KITITAS COUNTY

MEMORANDUM

TO: All Staff
FROM: Justin Turnbull, County Surveyor 
DATE: December 1, 2020
SUBJECT: County Survey Review of BL-20-00022 Lohnes

**BOUNDARY LINE ADJUSTMENT BL-20-00022**

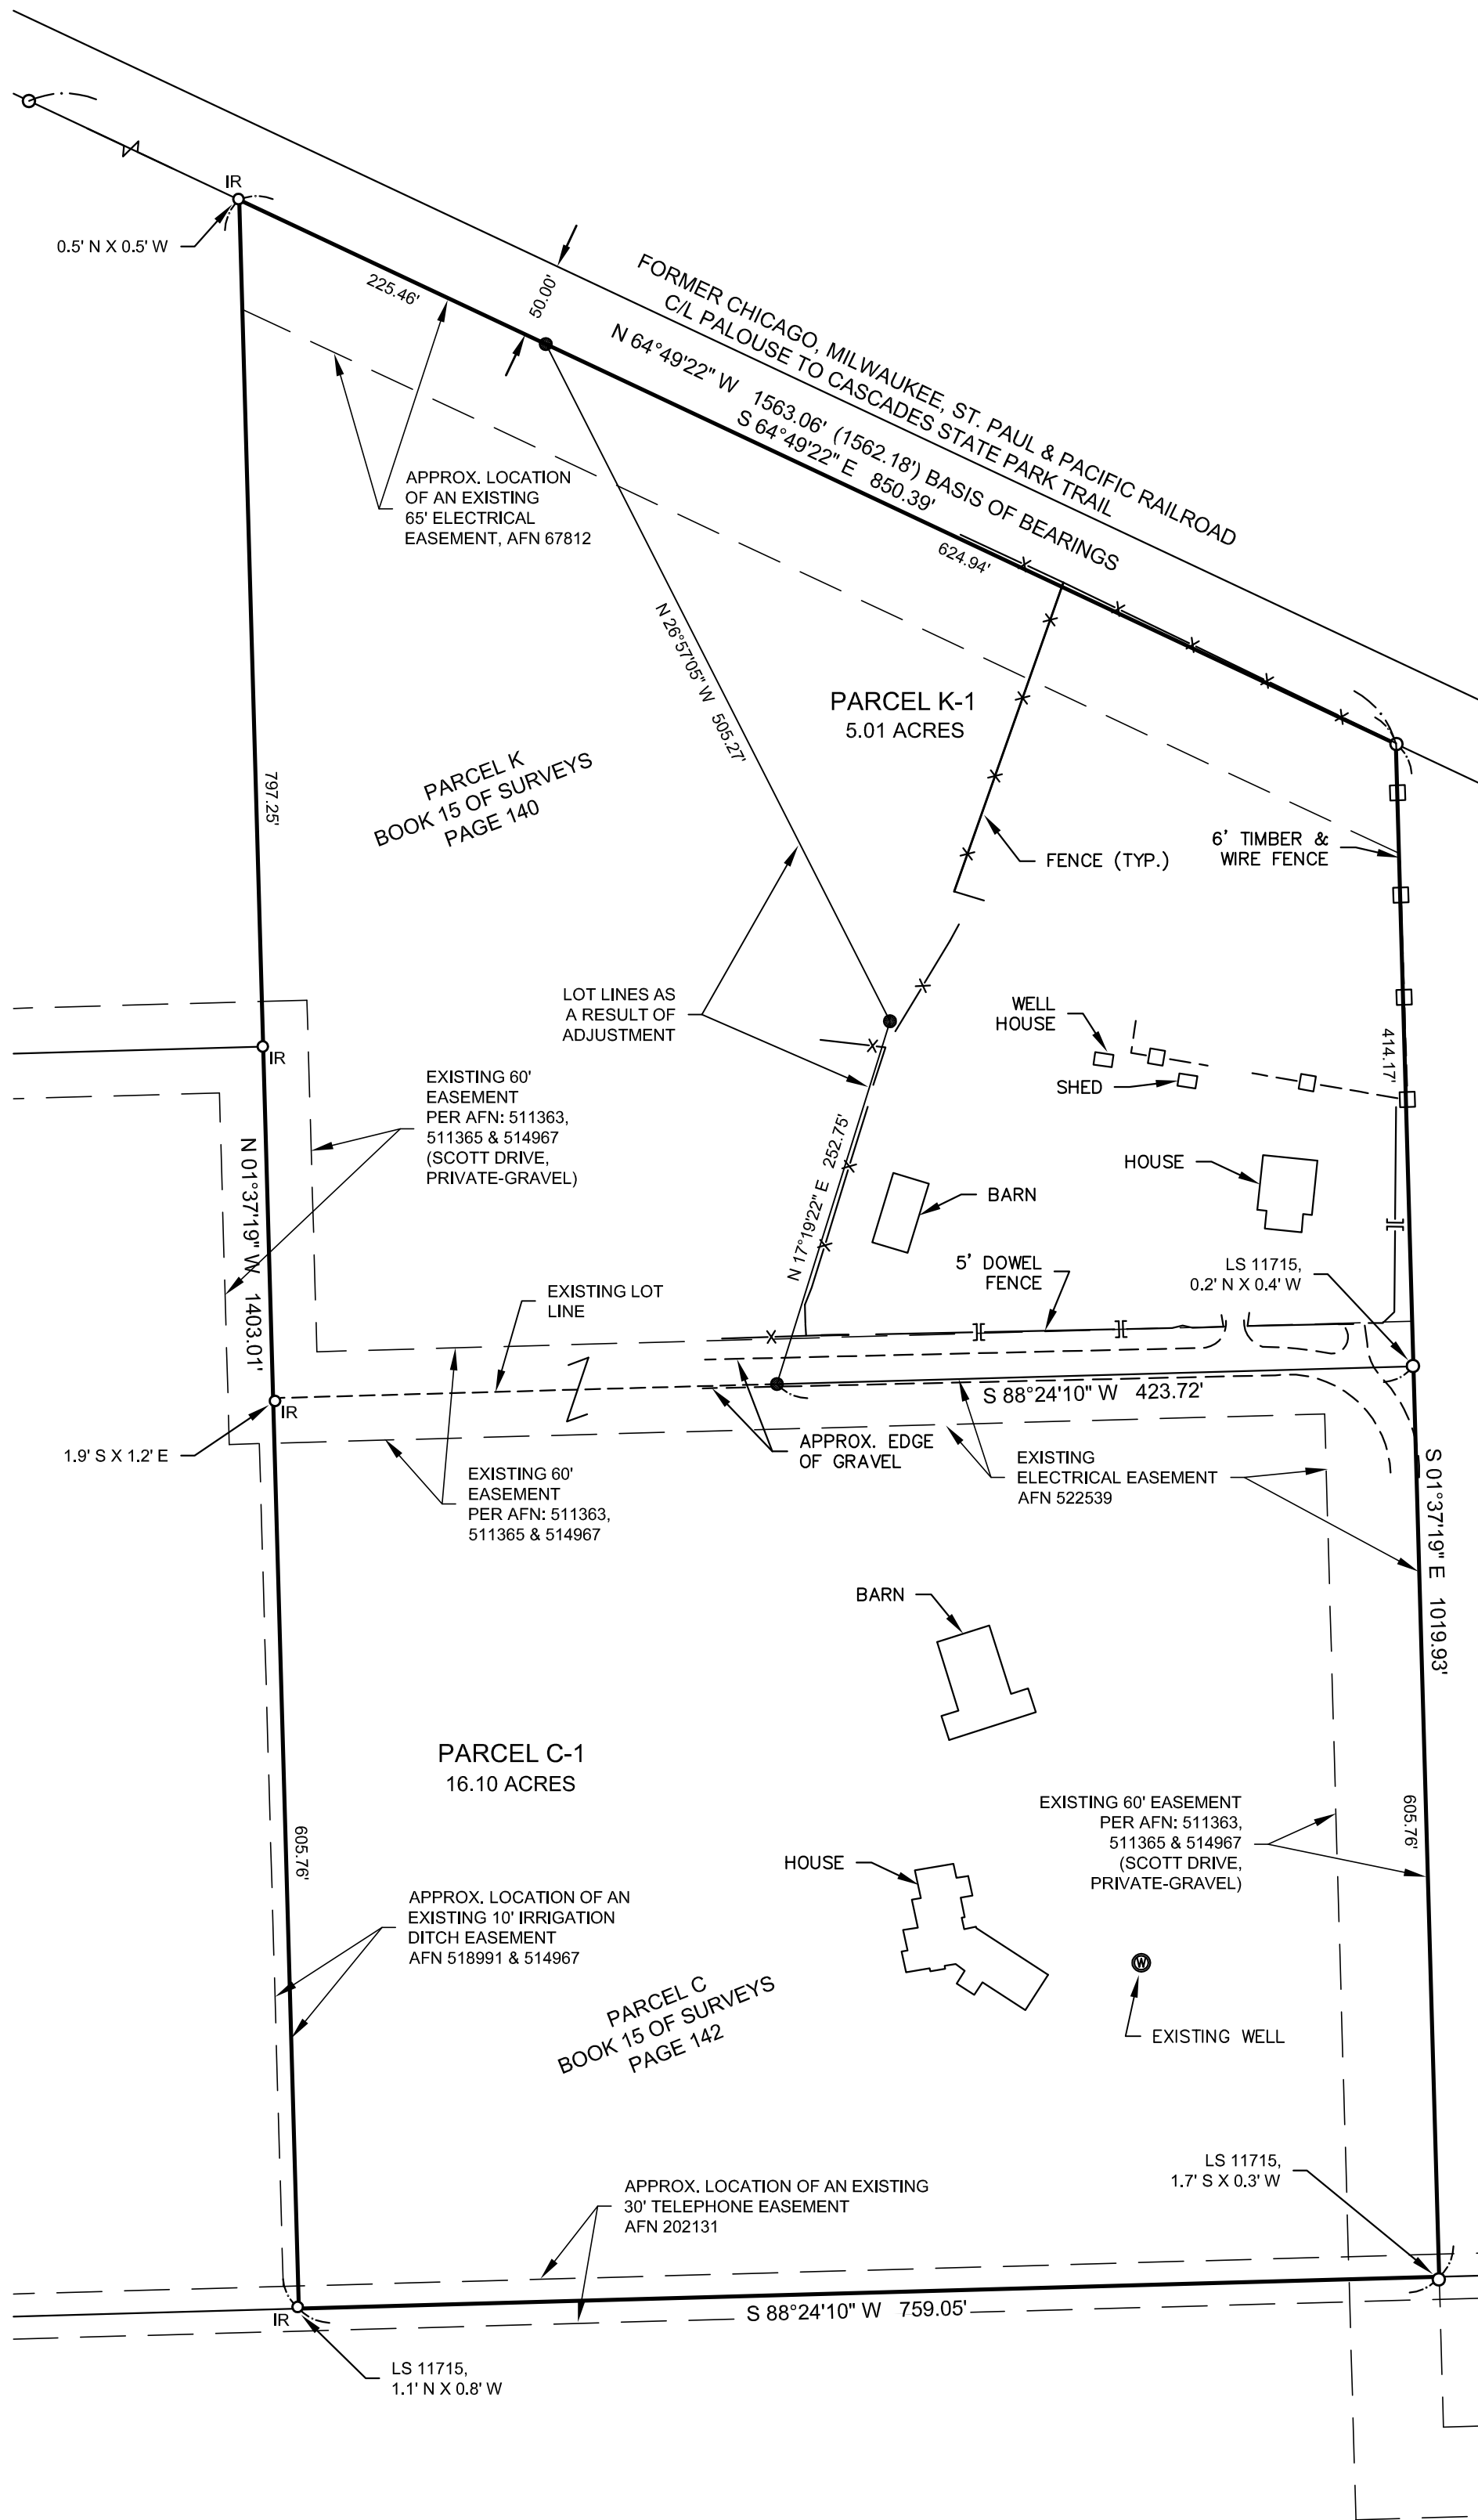
Existing Legal description-Tract 2, Parcel 1 should refer to Book 15 of Surveys, Page 140.
